February 28, 2020

Timberland

9027 SE 60<sup>th</sup>. ST.

2001-170

**A4**

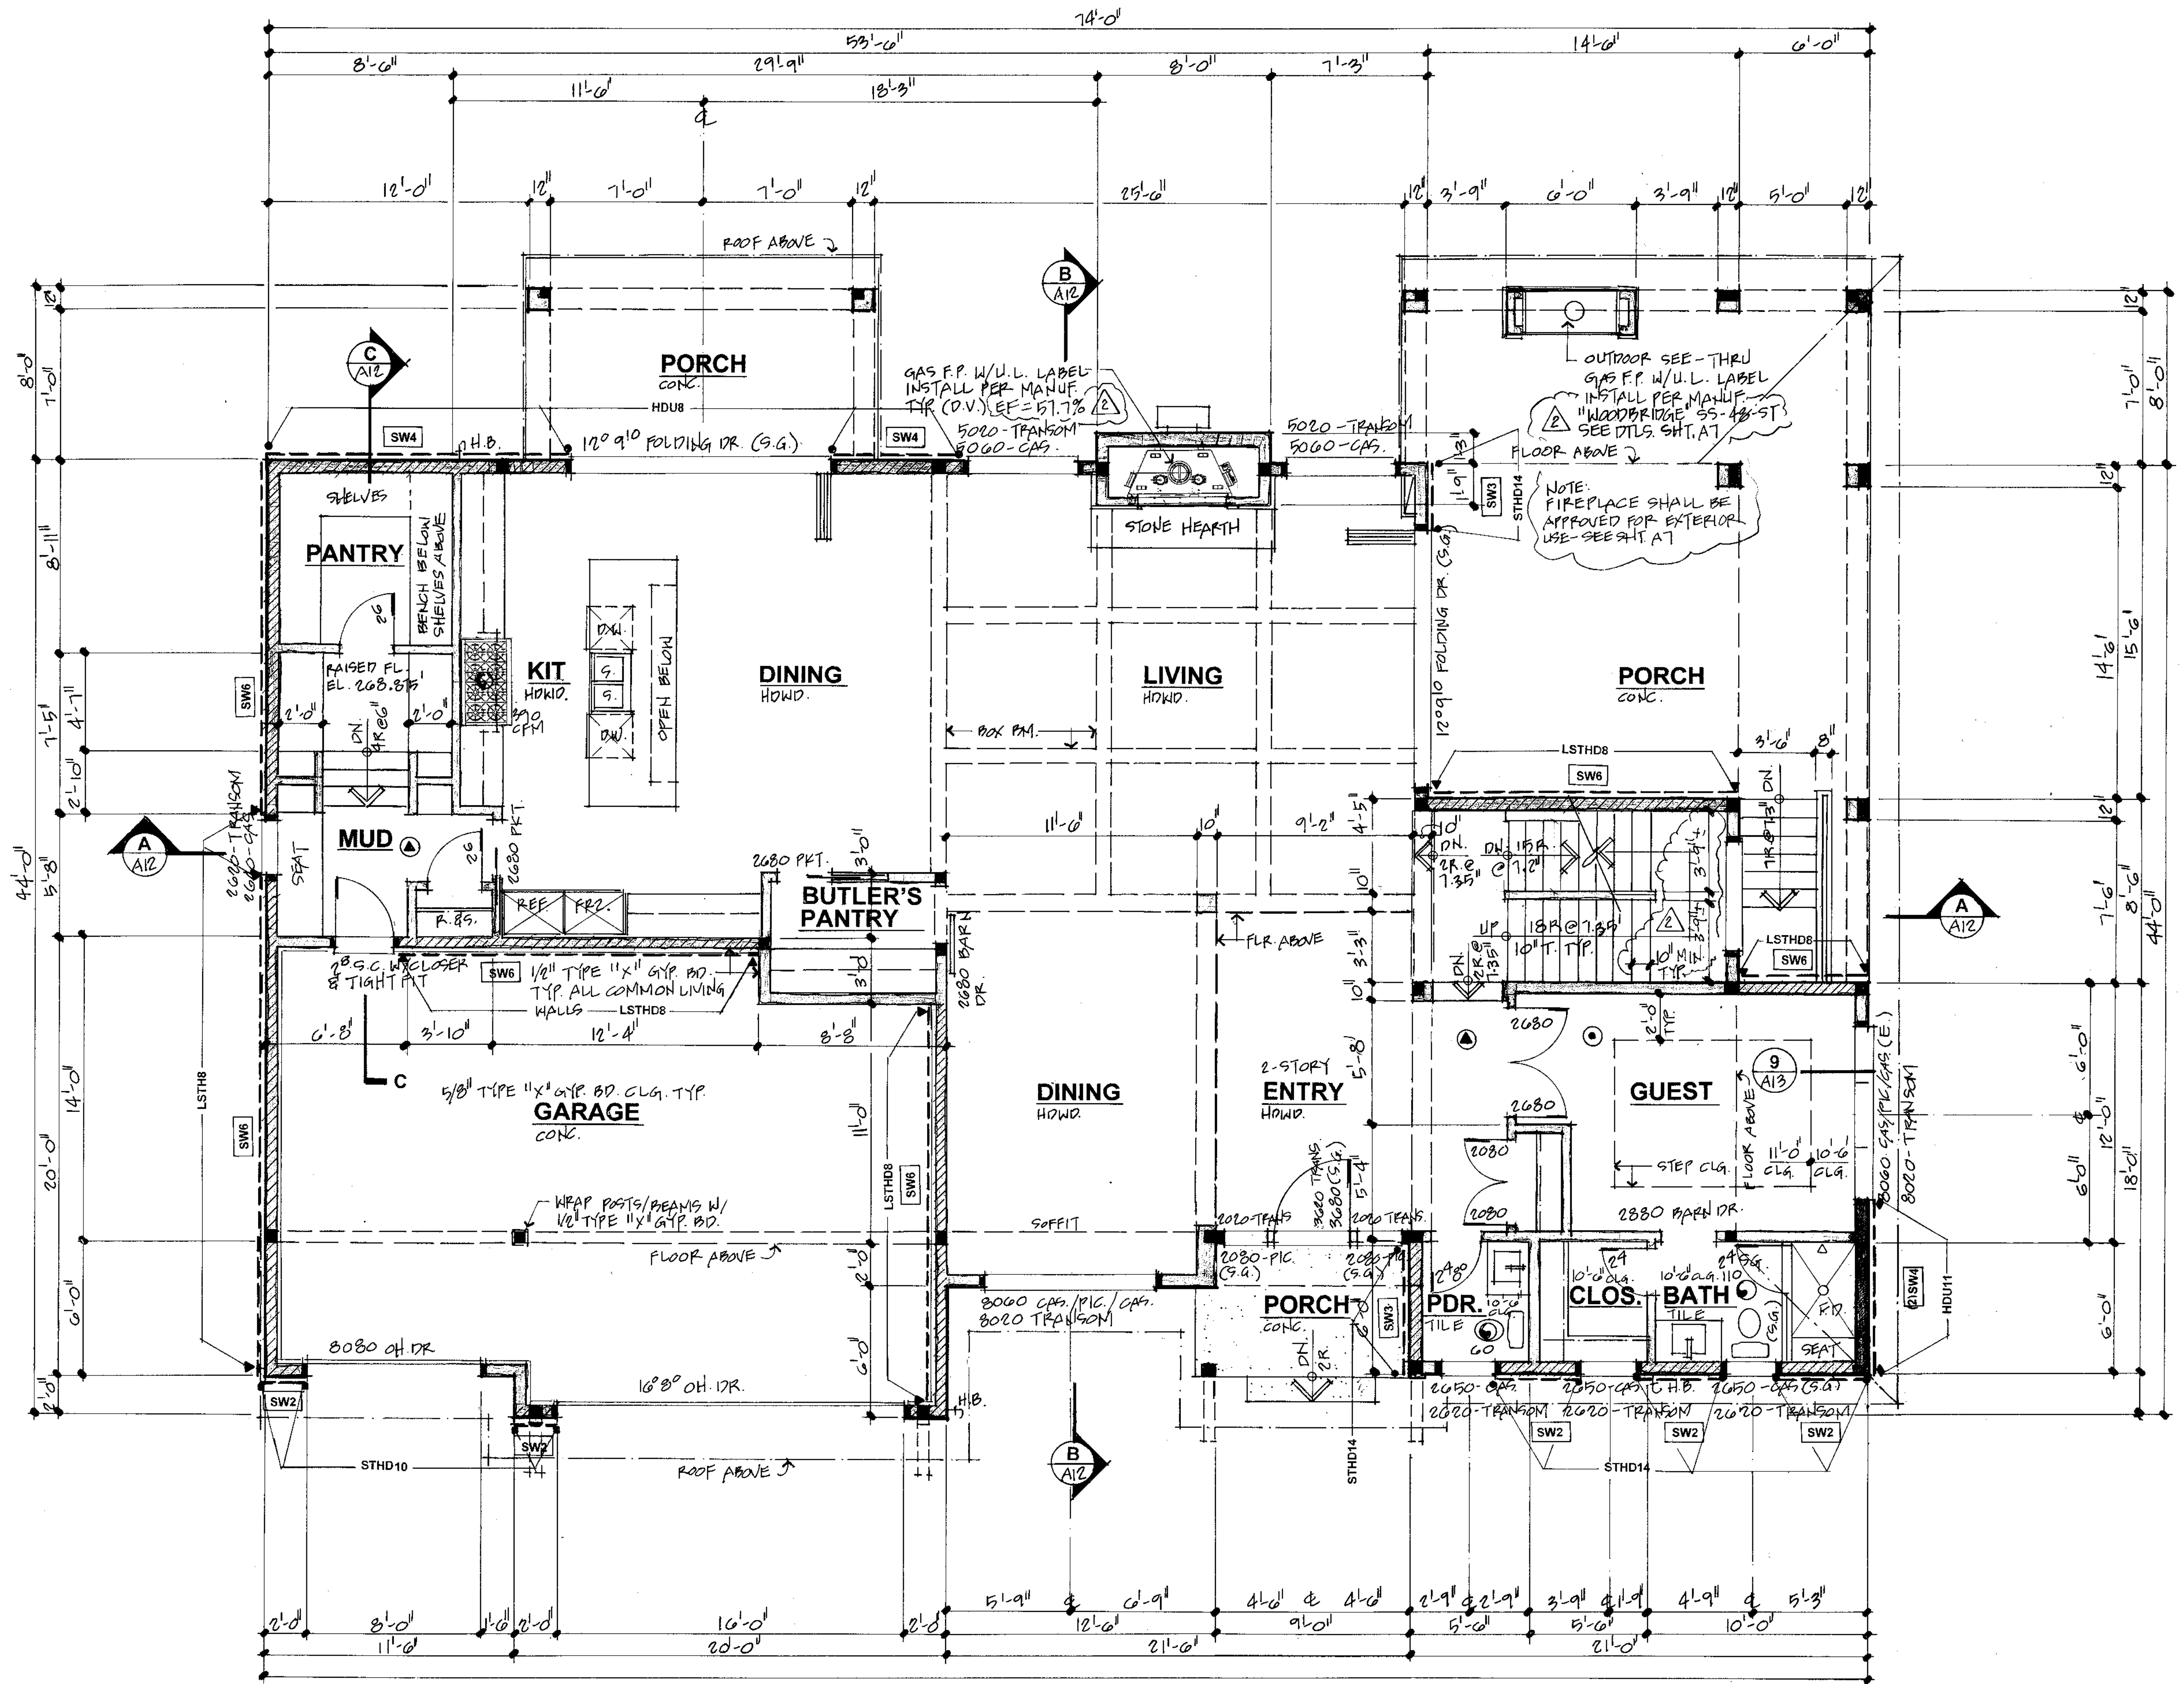
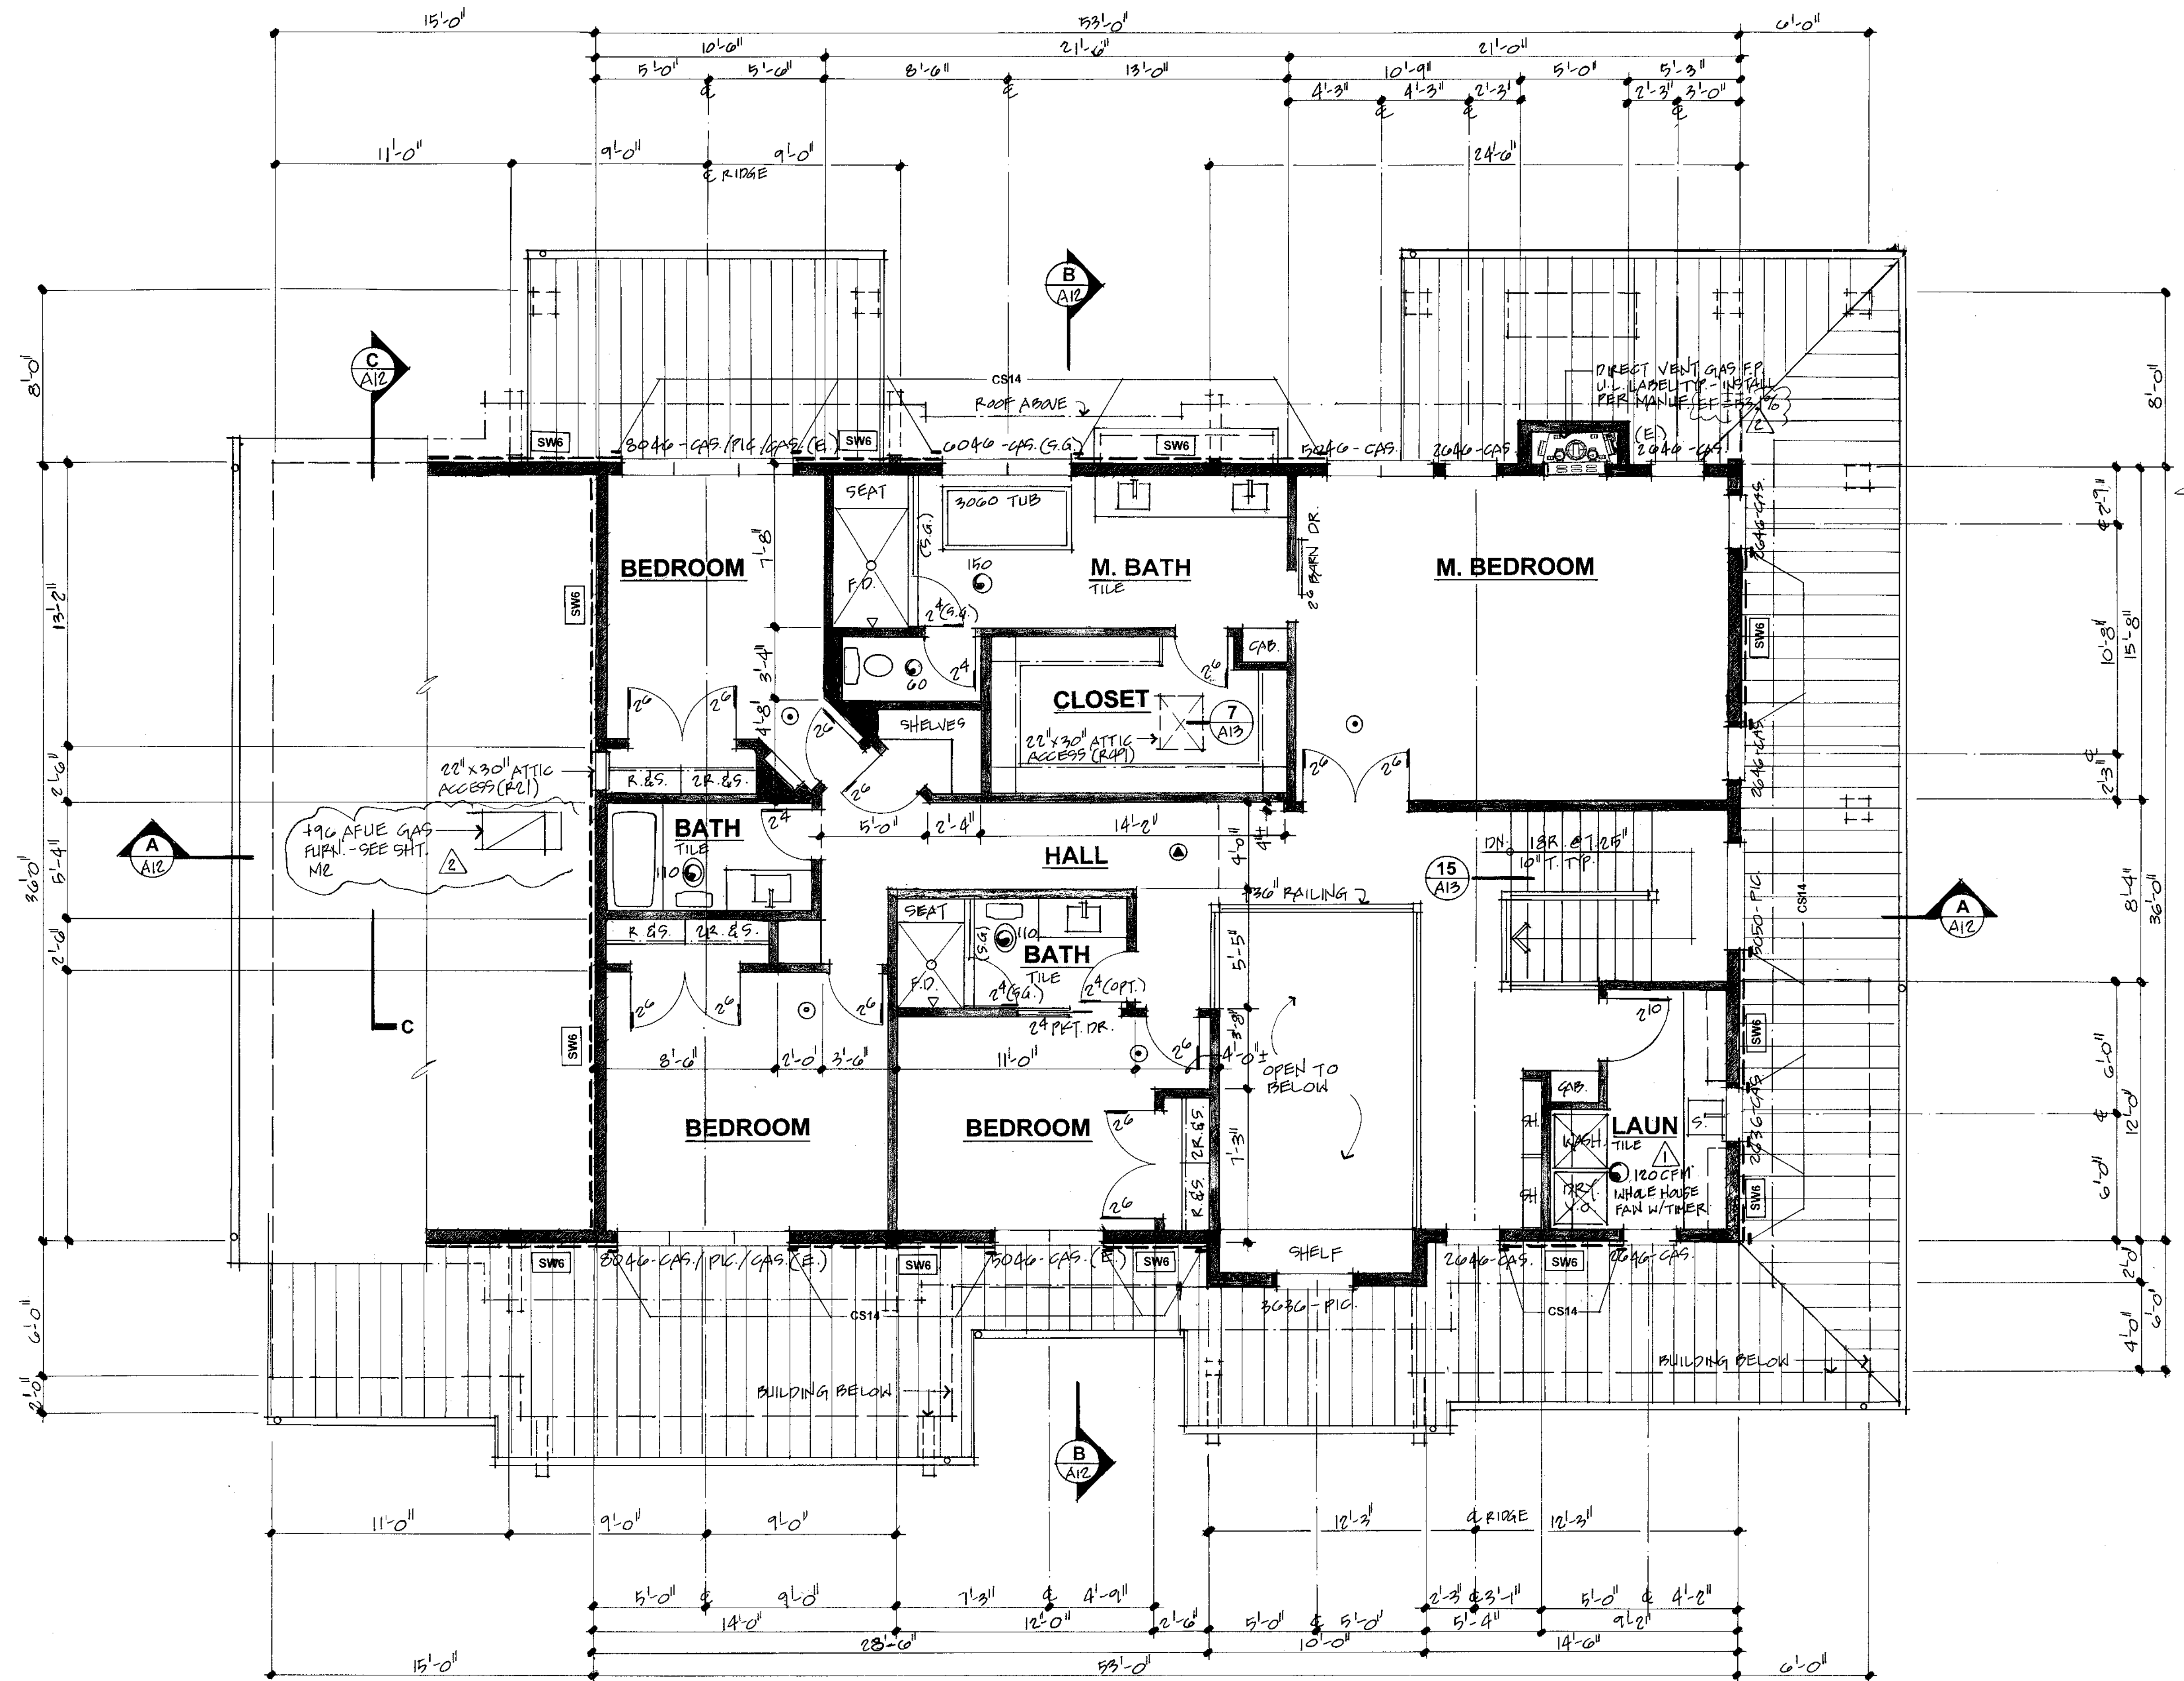
Added additional Whole House Ventilation notes sheet A4
